Exhibition of M2 Site within the North Ryde Urban Activation Precinct (SSD 5093)

Attachment A - Key Issues

FIGURE 2 – PROPOSED GFA ALLOCATION PLAN (SOURCE: BATES SMART ARCHITECTS)

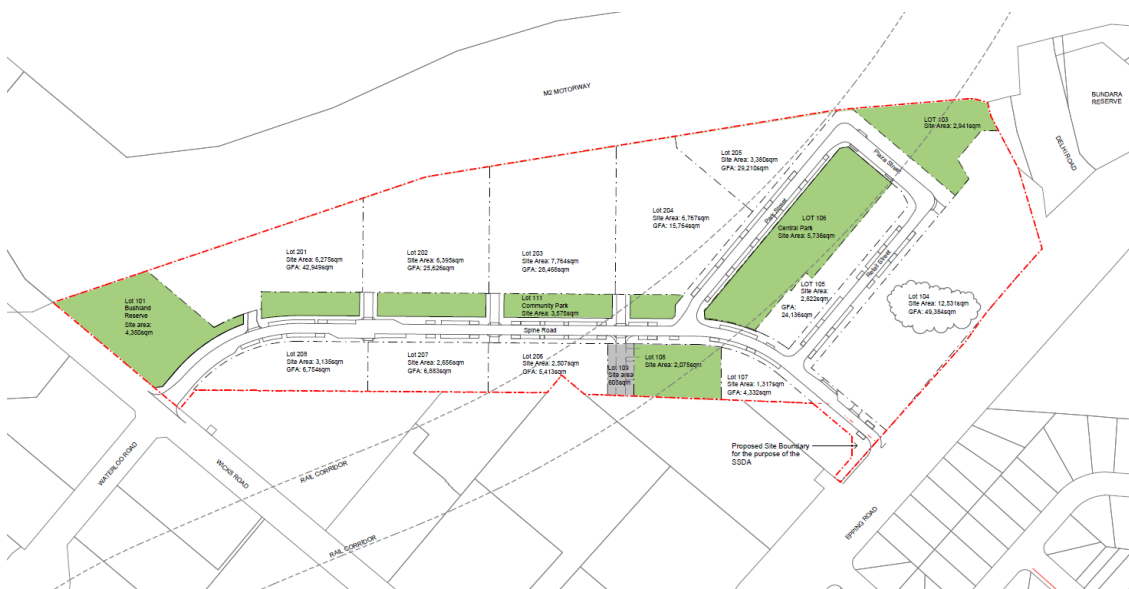
1. The proposed distribution of Gross Floor Area across the development lots varies from that envisaged within the Ryde Local Environmental Plan (LEP) 2010. Justification is to be provided for the substantial increase in GFA in the northeast corner of the site (Section W), noting that the floor space ratio controls within Ryde LEP seek to locate greater density in the centre of the site (Section X) which also benefits from proximity to public open space, the community facility and public transport.
2. It also appears that part of the community lot (Lot 103) has been included in the site area for the purposes of GFA calculations. The Department is concerned that the GFA intended for the community lot has been partially transferred to the development lots. This area should be excluded from the site area and the allowable GFA calculation for the development lots.

Site Plan

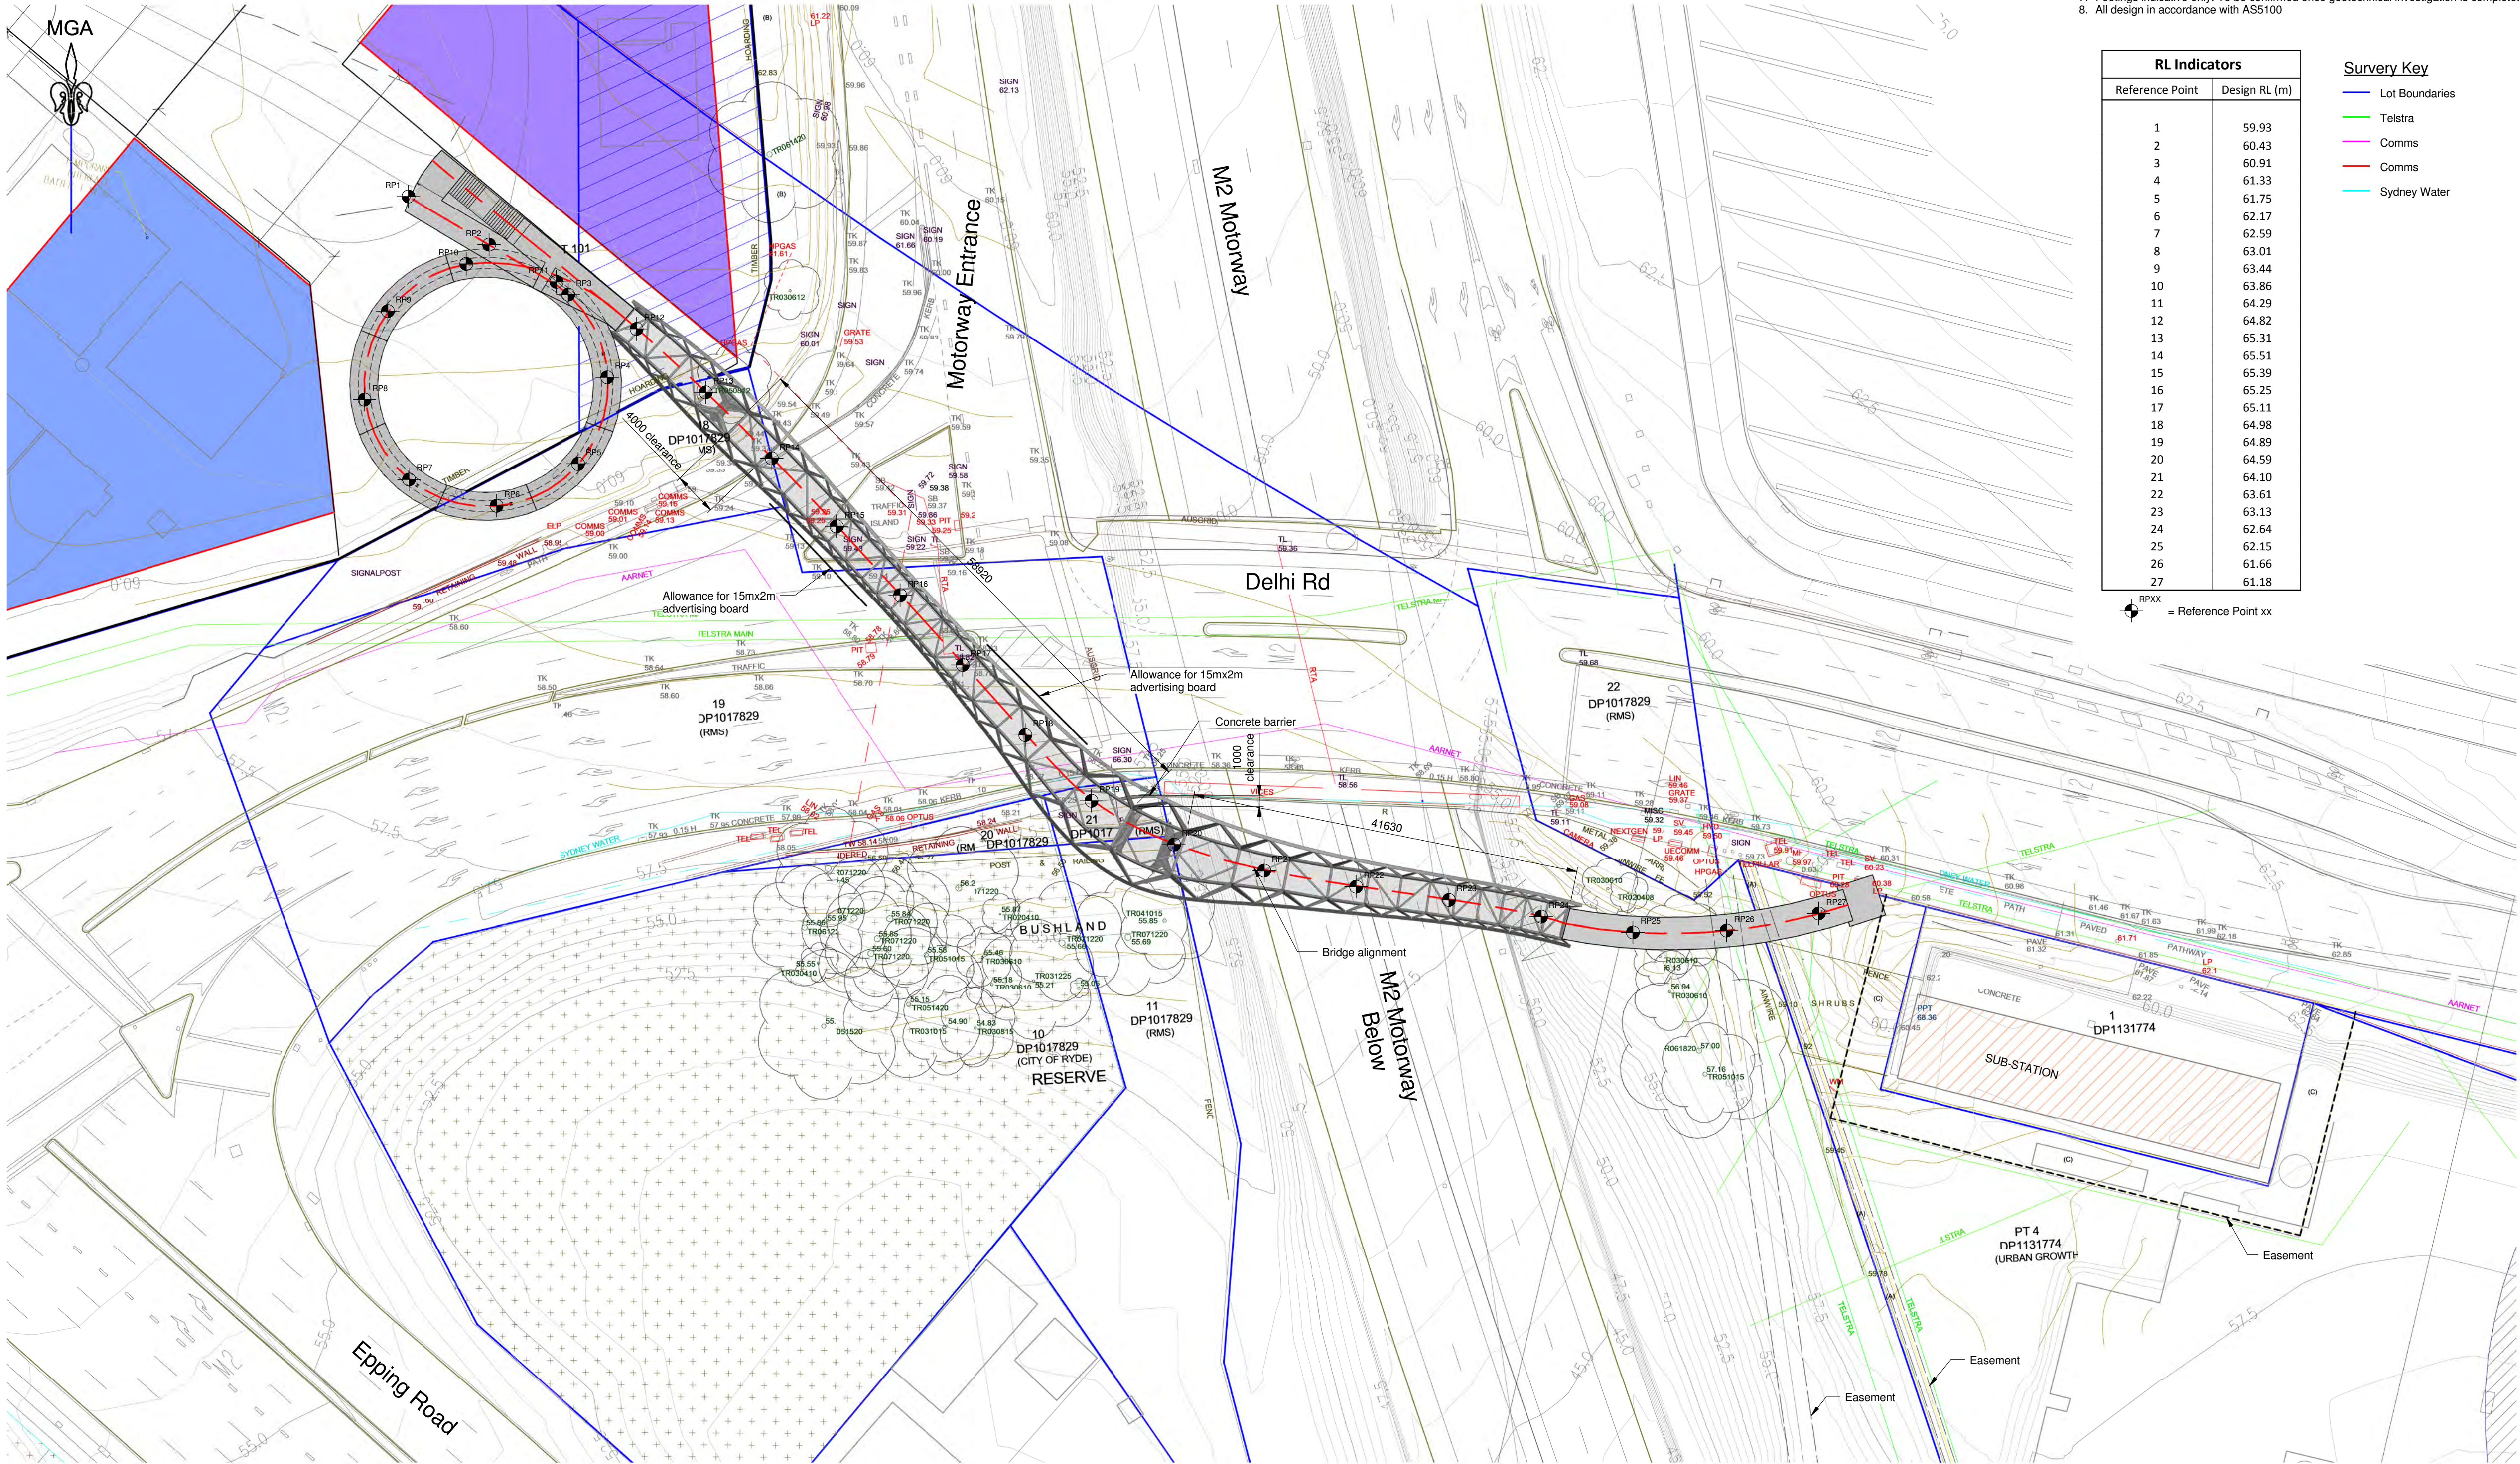
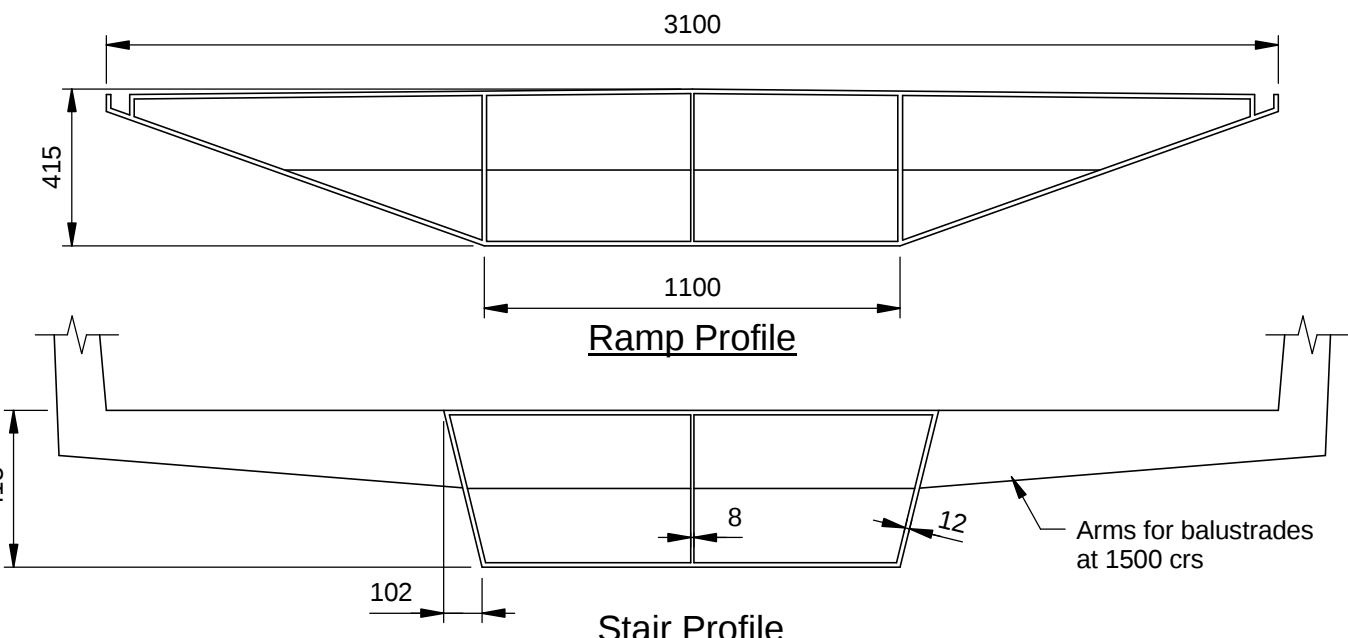
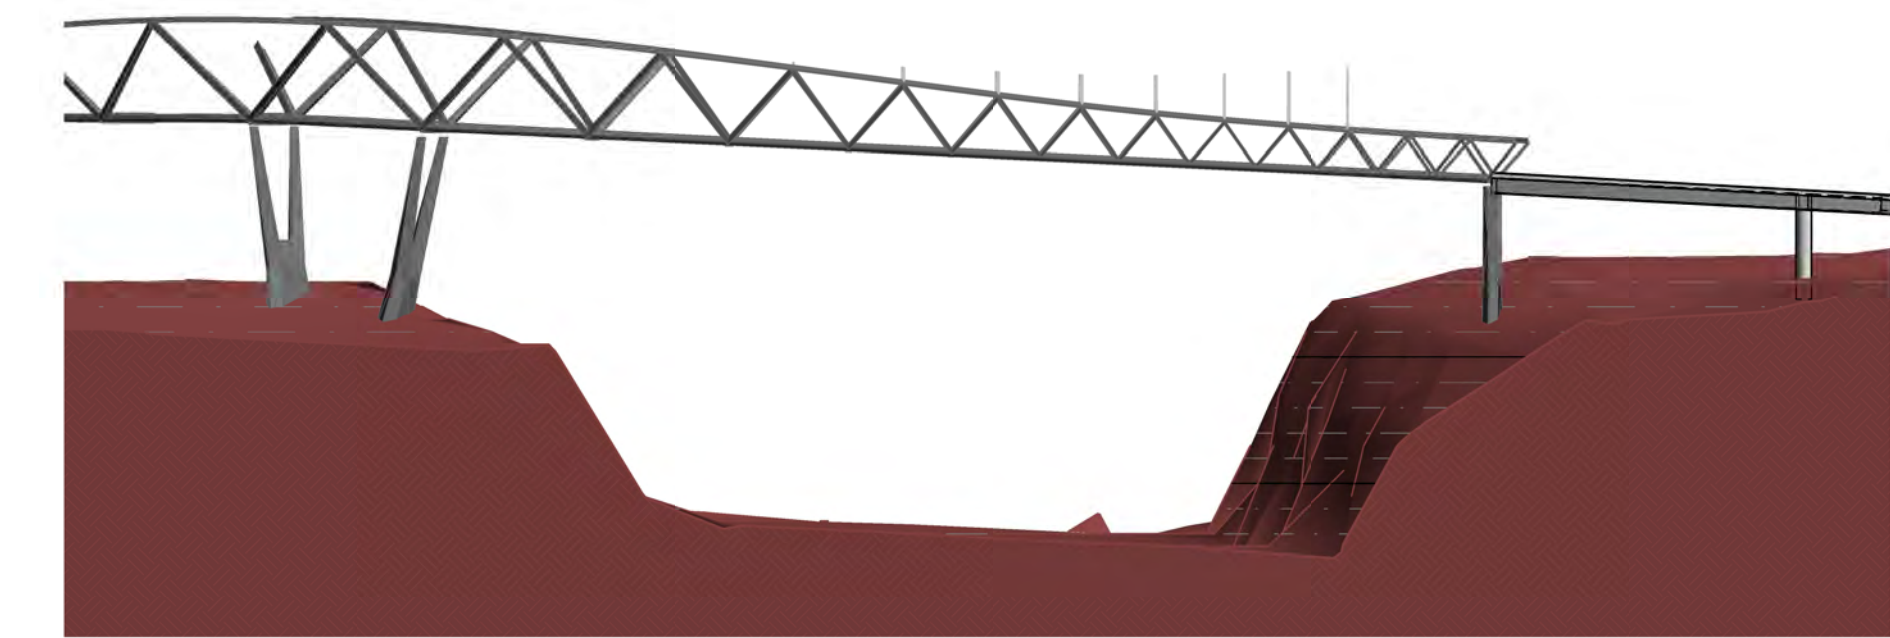
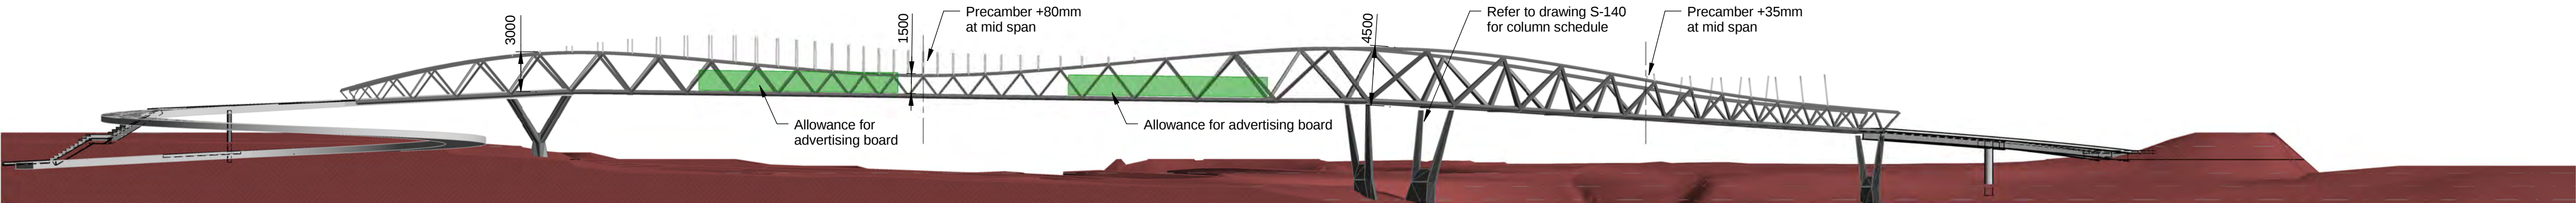
3. The proposed pedestrian/cycle bridge may have physical impact on Bundarra Reserve and adjoining RMS site in terms of both the support pylons and overshadowing. Detailed consideration should be given to the impact of the bridge on the Sydney Turpentine Ironbark Forest (STIF) community located within this area including:
 - measures to minimise impacts; and
 - whether any offsets are required.
4. Options for a revised bridge design should be provided which:
 - addresses any measures to protect the STIF community;
 - addresses the design issues raised by Council;
 - provides revised landing design/gradients within the site to address concerns raised by Council; and
 - provides further consideration of the landing location/design within the Station North site, including options to connect into the future plaza.

Full plans/details should be provided of the revised bridge design for consideration, noting that the EIS seeks Stage 1 development consent for the bridge.
